RE: Vantage Shoreline Substantial Development Permit, SD-18-00002

Grant PUD has the following specific review comments on the proposed revisions of the Crescent Bay Planned Unit Development:

A PORTION OF THE EAST 1/2 OF SECTION 30, TOWNSHIP 17 N., RANGE 26 E., W.M.

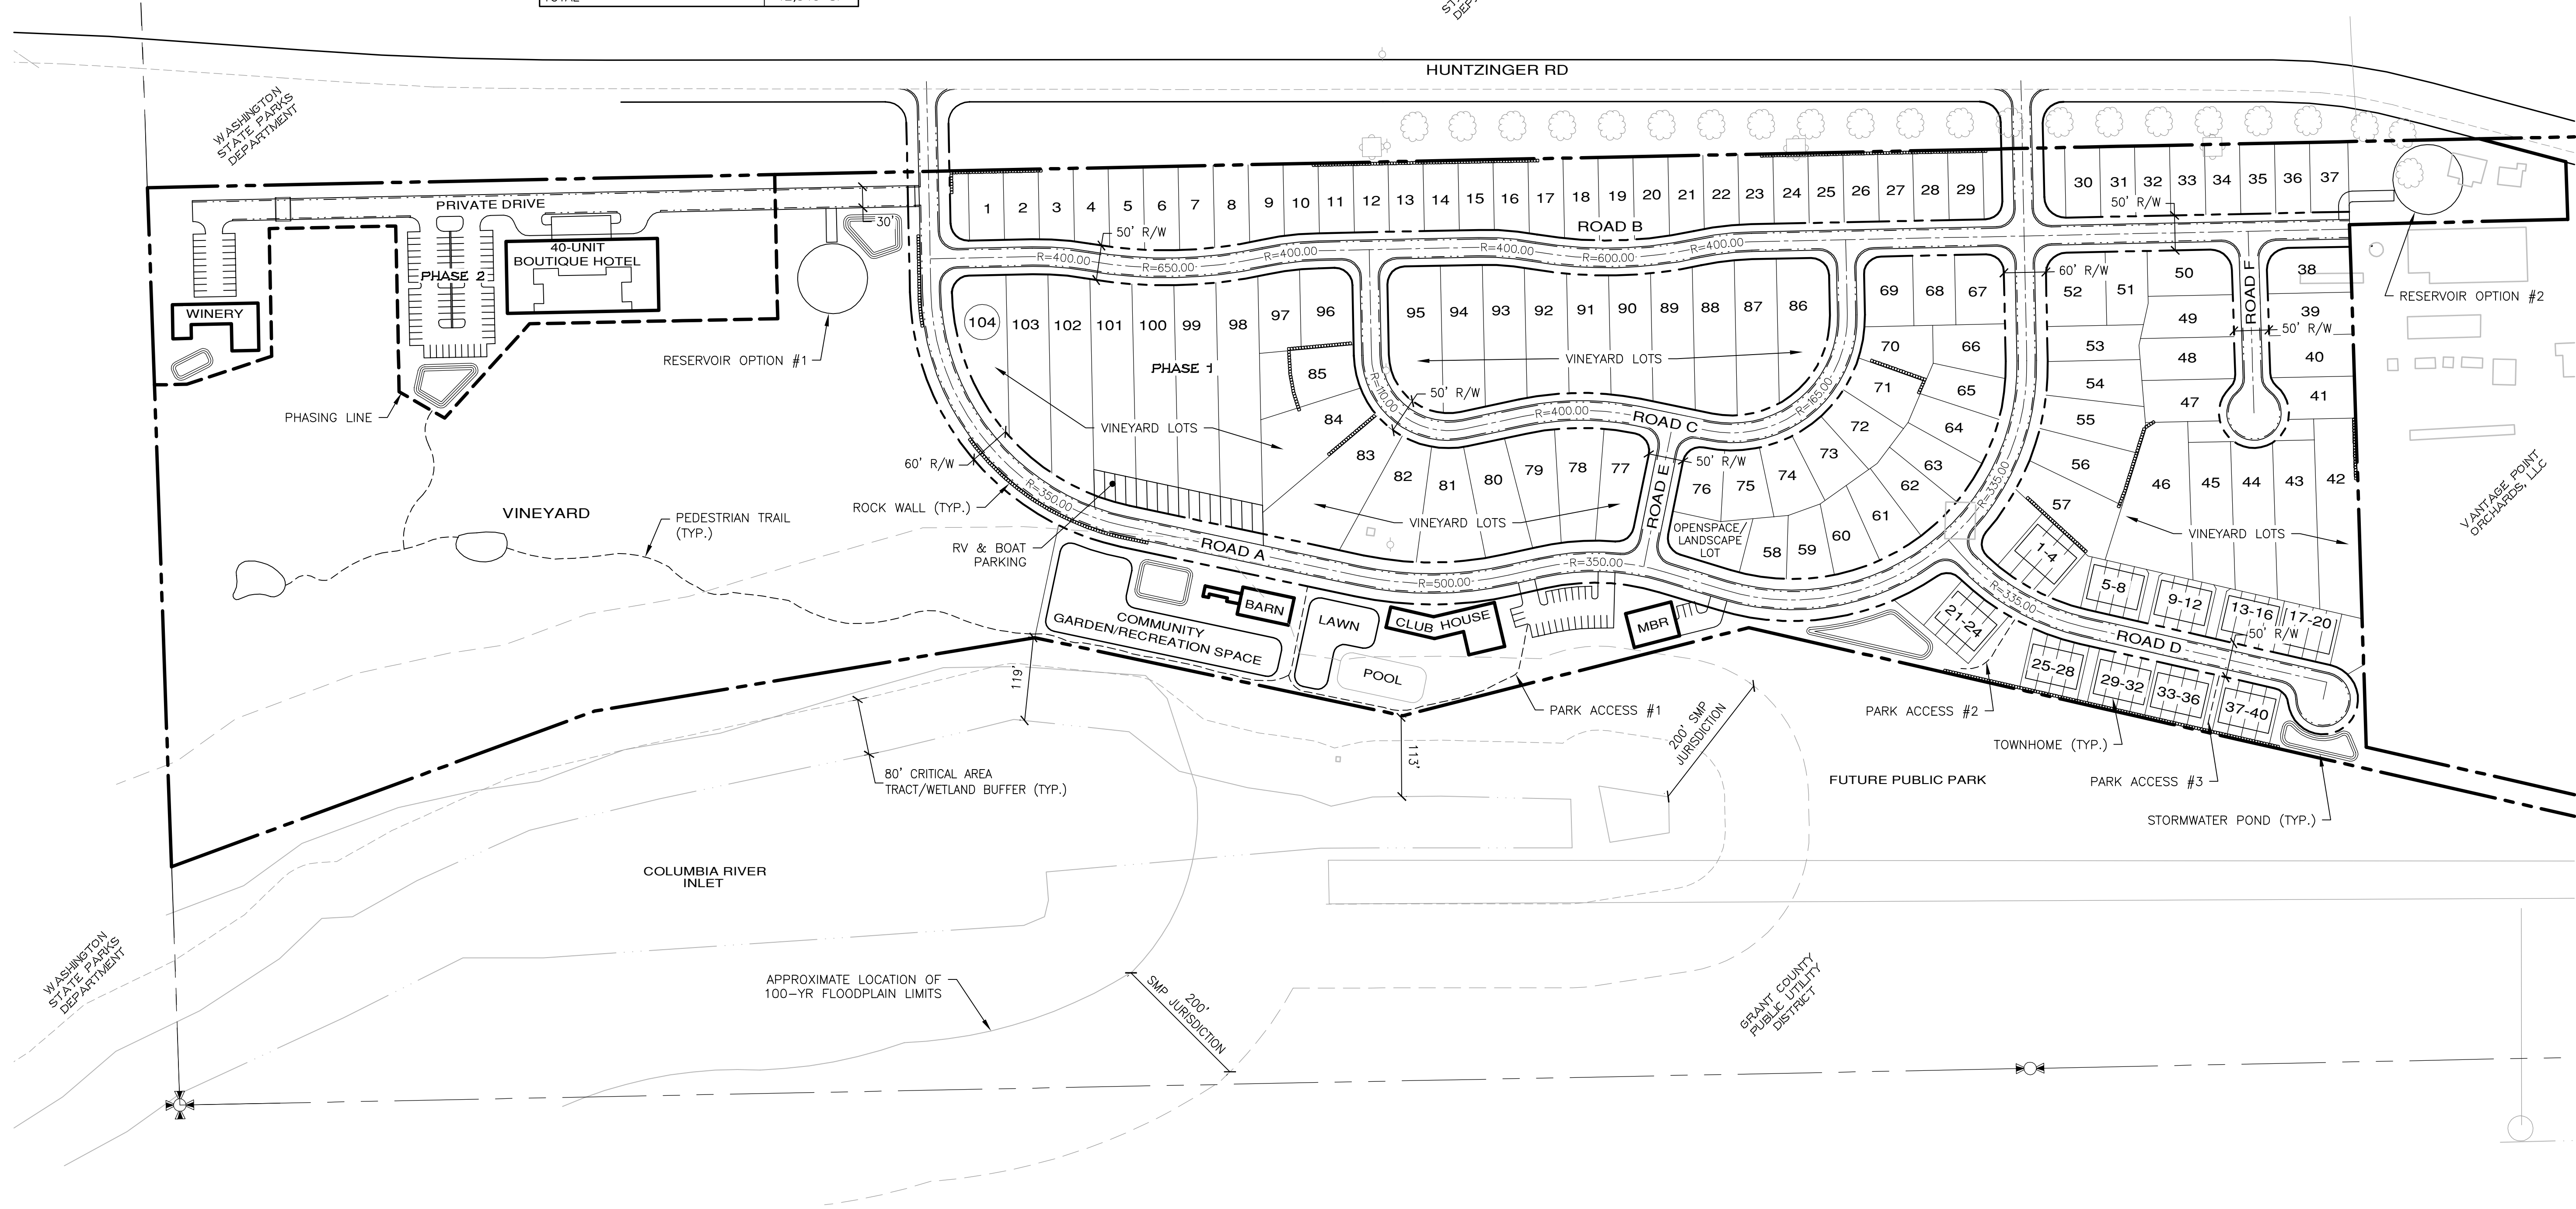
- 4) Grant PUD welcomes the applicant providing an easement from Huntzinger Road for public access to the lands and waters of the Project; however appropriate amenities, such as hiking/walking trails, are not included on the conceptual plan drawings for comment.

- 6) Grant PUD recommends installation of fencing (rock wall) to delineate private residential property from public property along the full length of the development's easterly property boundary to prevent encroachment on Grant PUD property and trespassing on private property, as well as to minimize ground disturbances and vegetation damage. Public access points should be built in to the fence system to provide access to the shoreline.
